Laurie Leader - Re: BP#2015-02862 50 Alden Circle

From: Joshua Letarte <JoshuaLetarte@msn.com>
To: Laurie Leader <LRL@portlandmaine.gov>
Date: 1/25/2016 11:08 AM
Subject: Re: BP#2015-02862 50 Alden Circle

Subject: BP#2015-02862 50 Alden Circle

EXISTING FLOOR PLAN

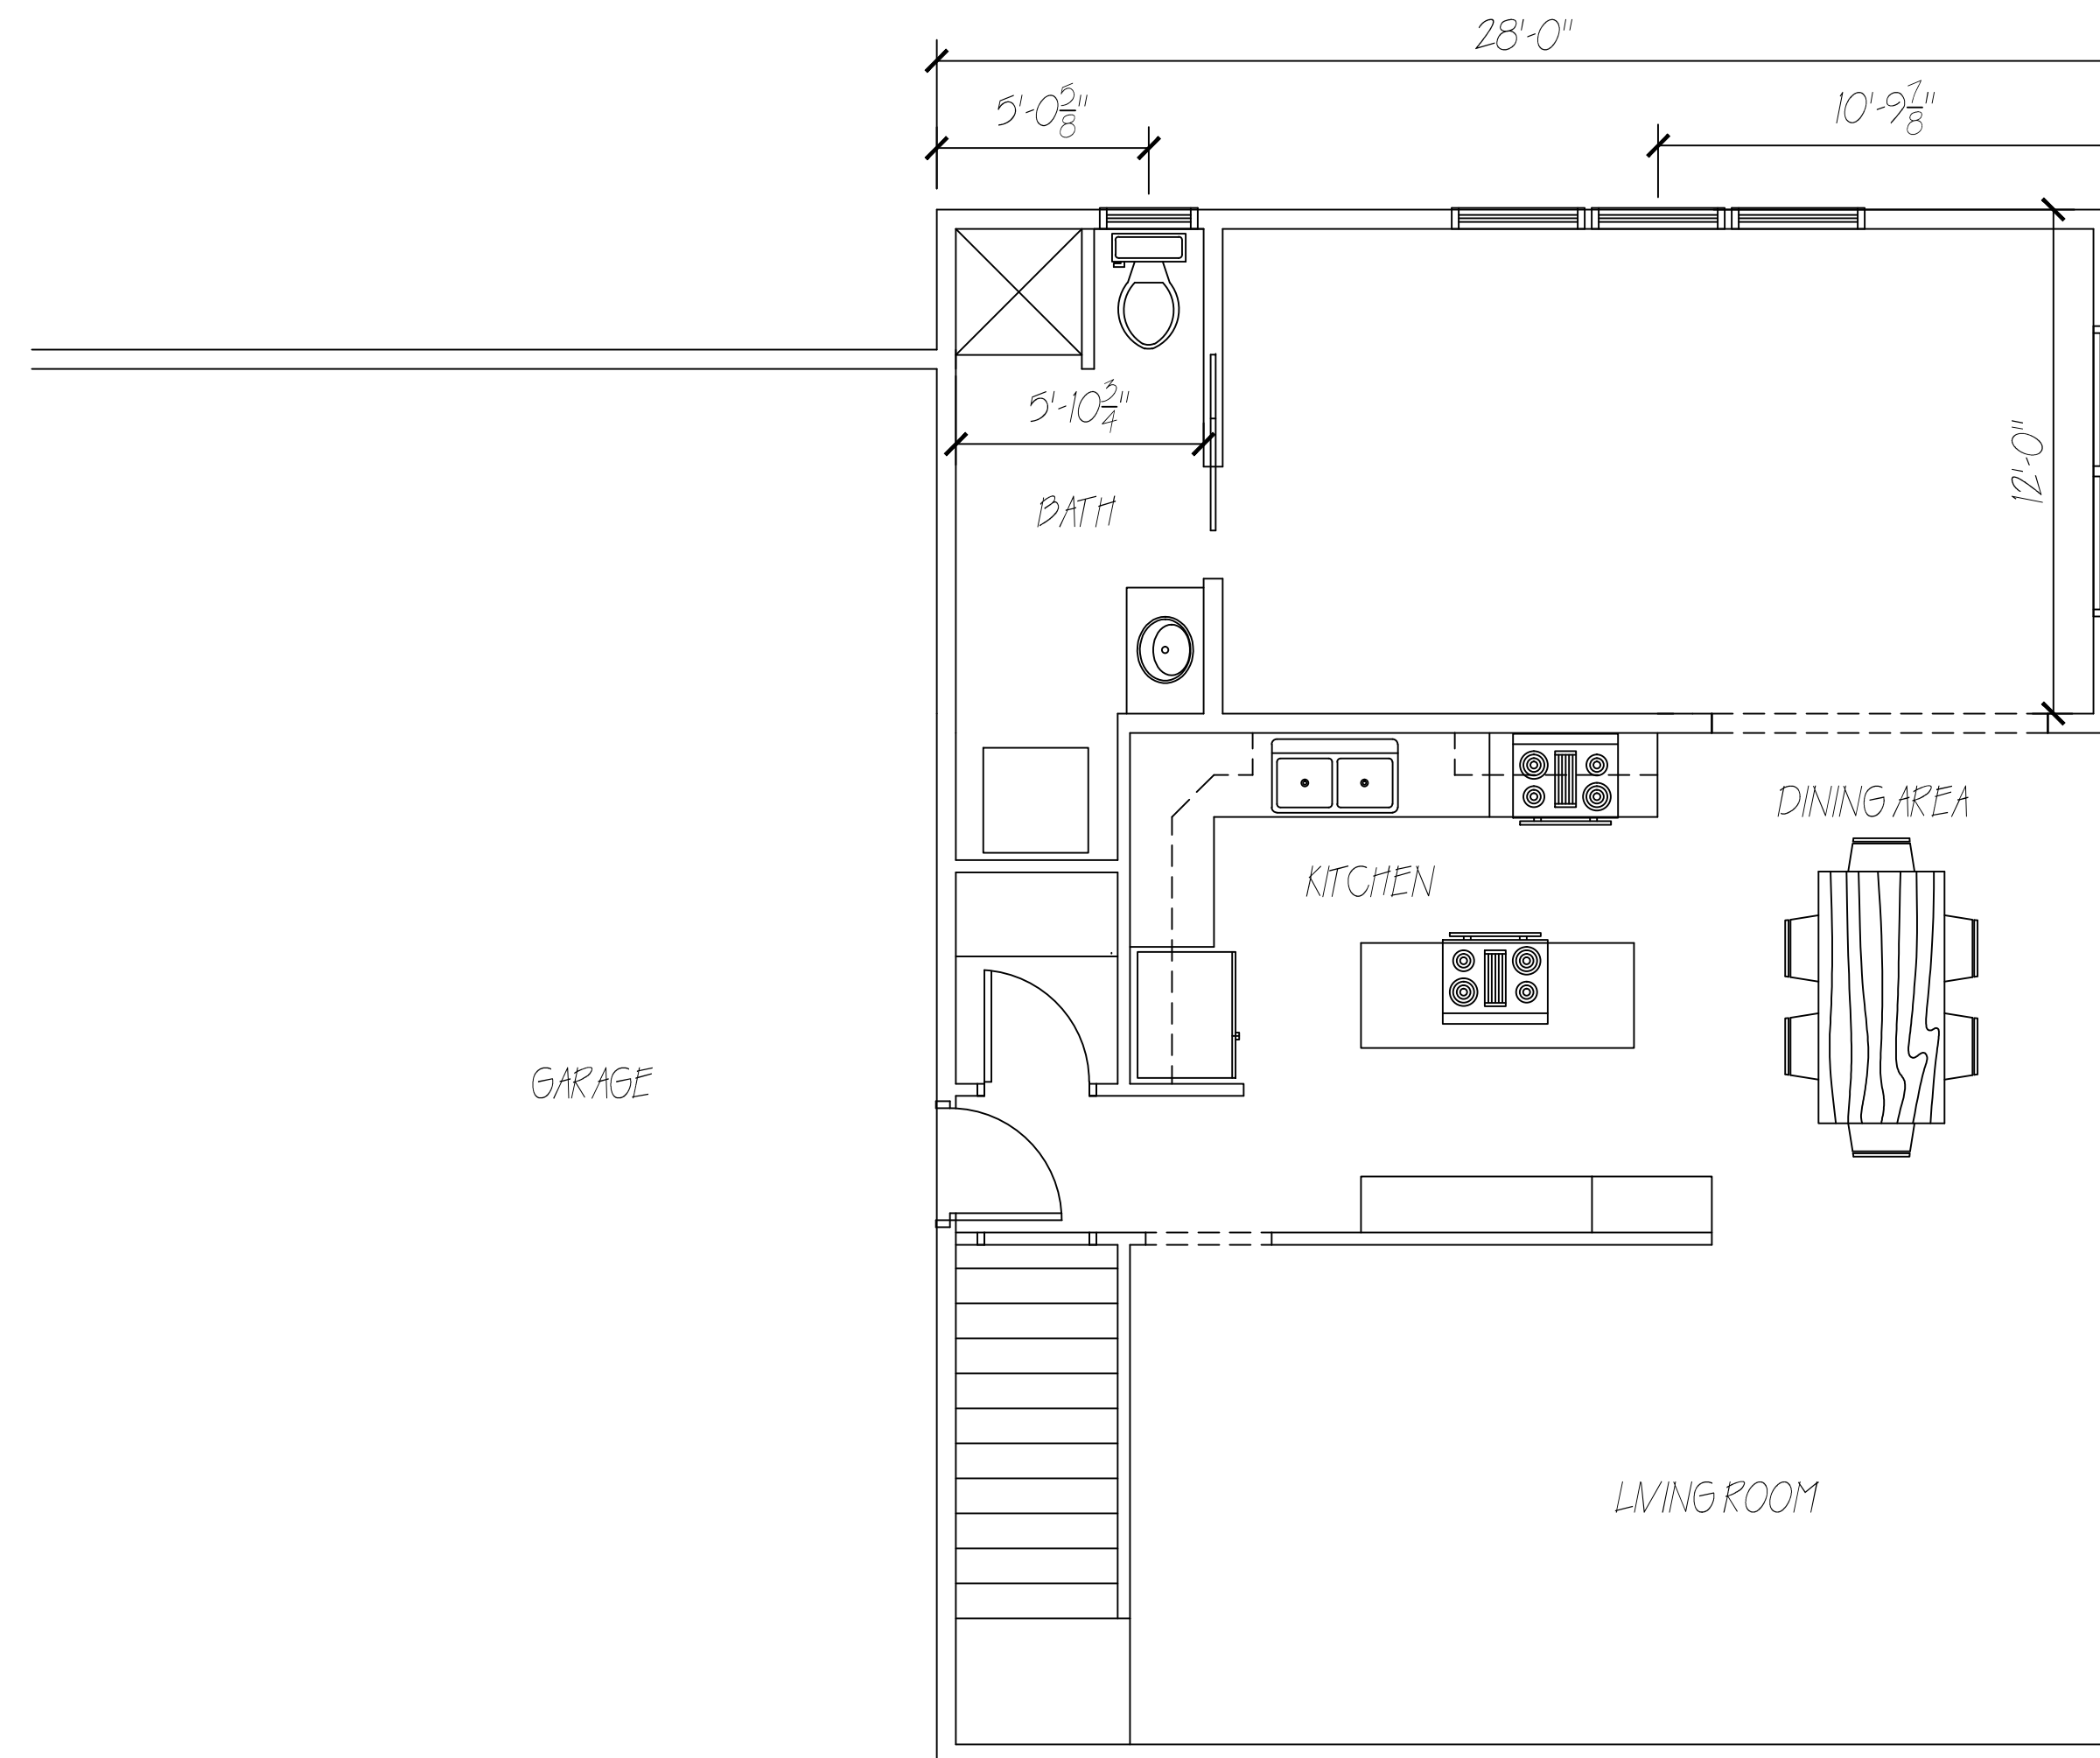
I am unclear how the entire bulkhead opening can remain in place to access the crawl space. Is the opening height greater than the height of the crawl space? If so, please clarify how the existing opening will be reworked to access the crawl space.

The existing plans do not show an existing bulkhead. Please revise both the existing an proposed plans showing the bulkhead and specifically where the bulkhead is and the exact size of the opening between the basement and the crawl space.

The concrete foundation outside of the house is staying in place with the stairs and the door into the basement. If I need more headroom I will cut the concrete wall of the bulk head but I don't think we need to. The metal bulk head doors will be removed.

Here is an updated plan showing the bulk head. We are going to keep it and use for access to the new crawl space.
Let me know.
